From: Rik (Studio Webb Architects)
Sent: 08 May 2025 06:56
To: Iqraa Malik
Subject: Re: 000_Ref. Application K/8/25/HH
Attachments: 21012_GA.01 (Proposed Plans).pdf; 0000_8 Coastal Rd (Biodiversity Enhancement Statement).pdf

Re. Application Property : 8 Coastal Road, BN16

1 Proposed Roof Plan
Scale: 1:100

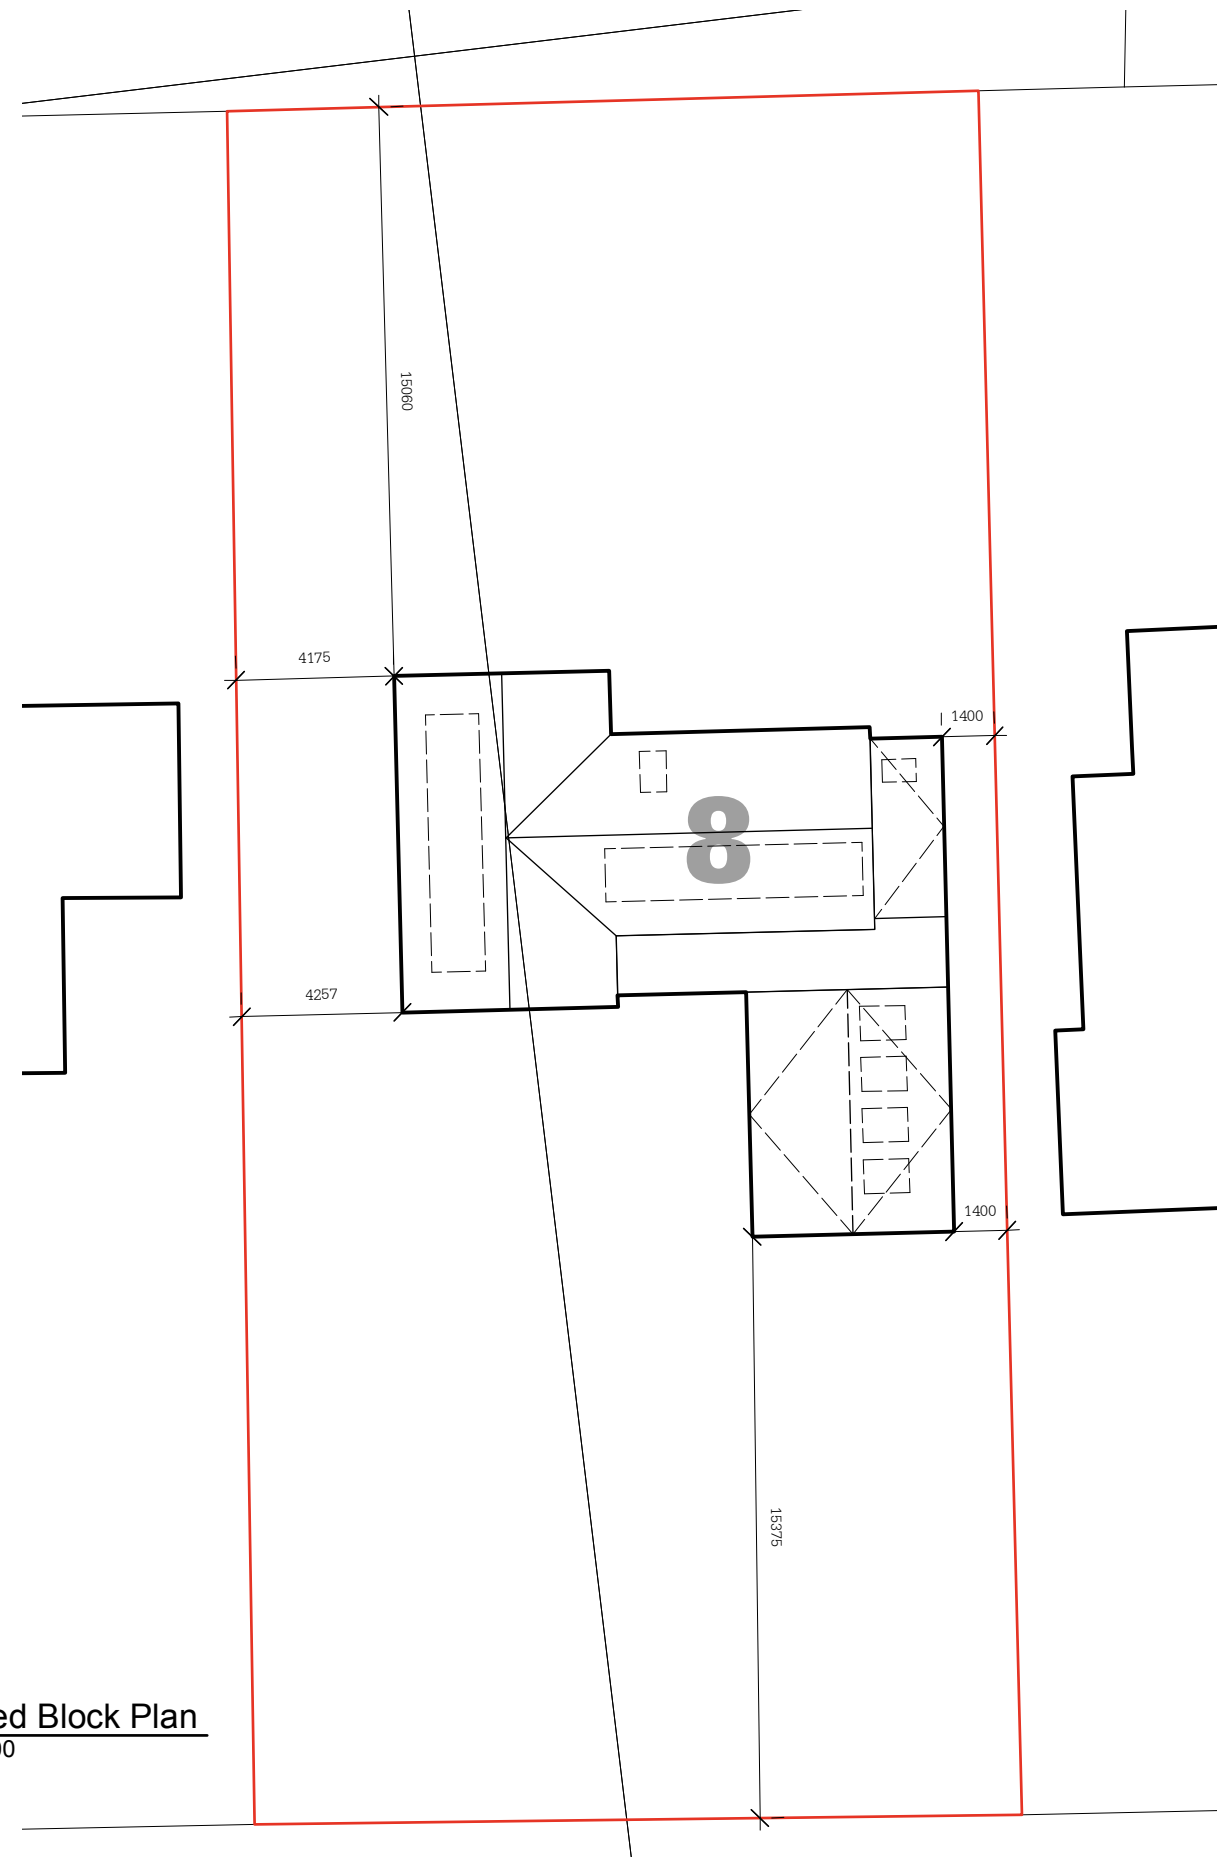
Unfortunately, this application is still invalid as you are required to show the proposed PV array on the proposed roof plan, please review and amend.

Please find enclosed updated GA.01 (Roof plan), plus the Biodiversity Enhancement Statement.
